WELWYN HATFIELD COUNCIL – DEVELOPMENT CONTROL
DELEGATED REPORT

APPLICATION No:	S6/2009/2273/FP
------------------------	------------------------

The application seeks full planning permission for extending the existing dwelling with a two storey side extension on the east side of the dwelling which would be approximately 4.3m wide and a detached double garage with a pitched roof following the removal of the existing garage/store outbuilding.

HIGH LEVEL BAT ENTRY THROUGH GABLE TILE HANGING - 1:10

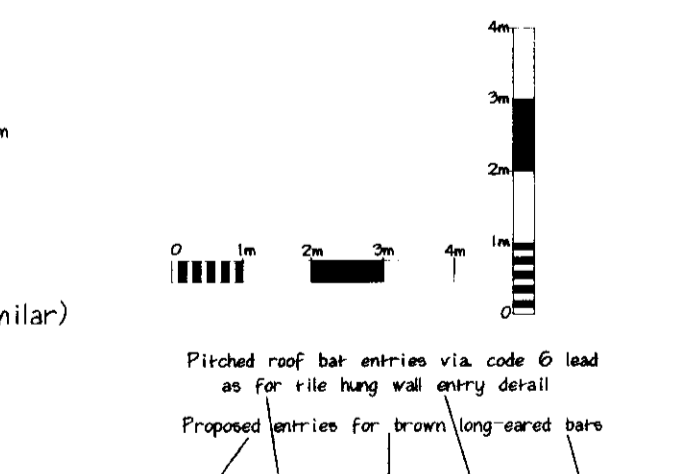
The reason for the increase in the height of the garage roof is to provide accommodation for bats as part of the mitigation strategy put forward by the applicants. Such a requirement was highlighted as a need in the previous 2008 application, although this did not form part of the design proposals for the garage.

PROPOSED ELEVATIONS - 1:100

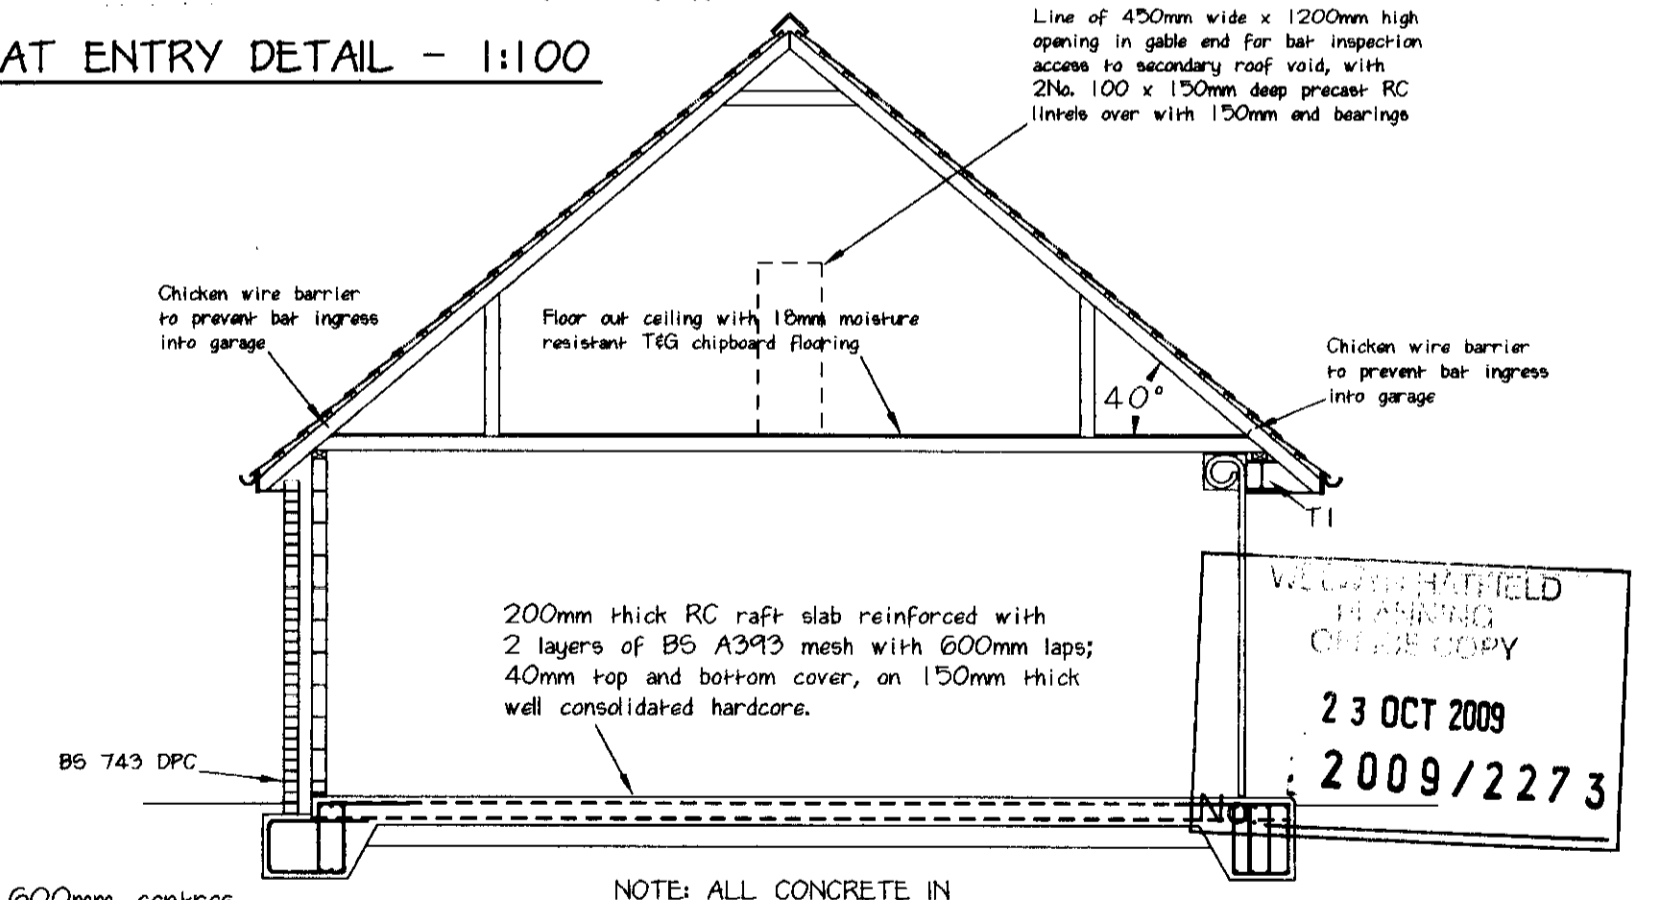
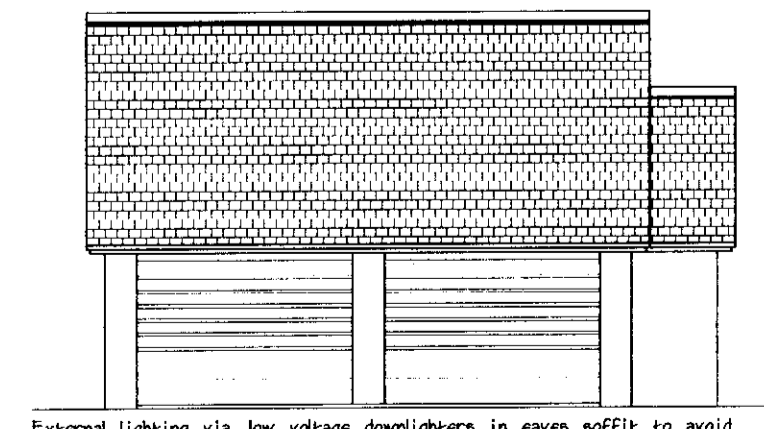
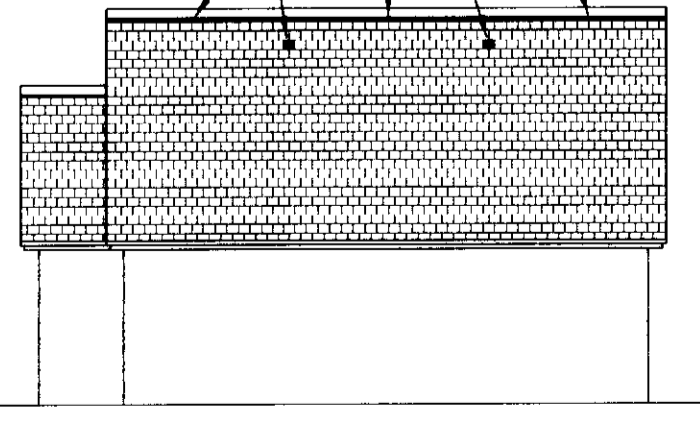
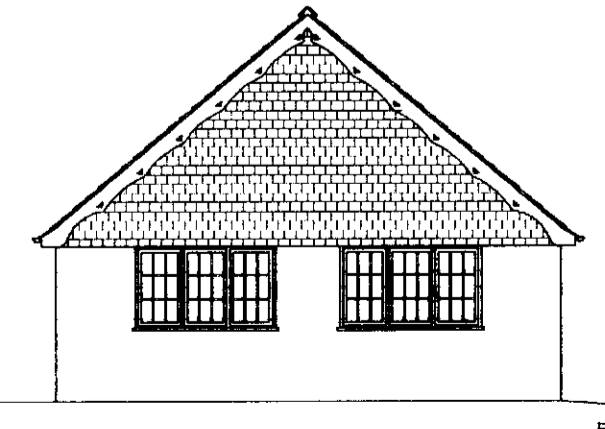
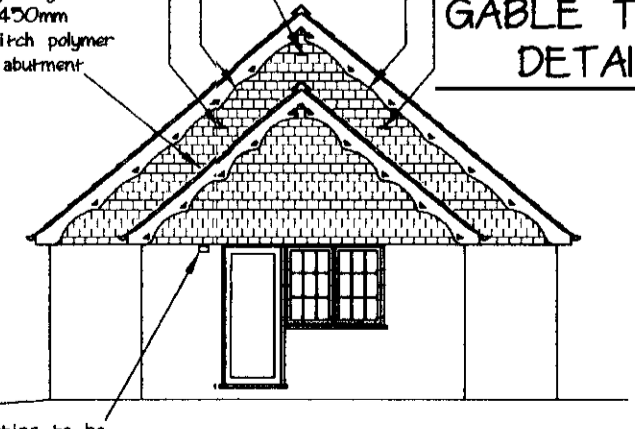
The new garage differs from the previously approved mono-pitched roof garage as a pitched roof approximately 5.5m high with gable ends is proposed. This increases substantially the visual impact and bulk of the building and so would have a substantially greater impact on the openness of the Green Belt. This increase compared to the existing outbuilding it would replace and the 2008 approval would be very significant and would harm the visual amenity of the Green Belt, particularly as it would be seen from the public highway.

The design of the garage is in keeping with the character of the existing dwelling.
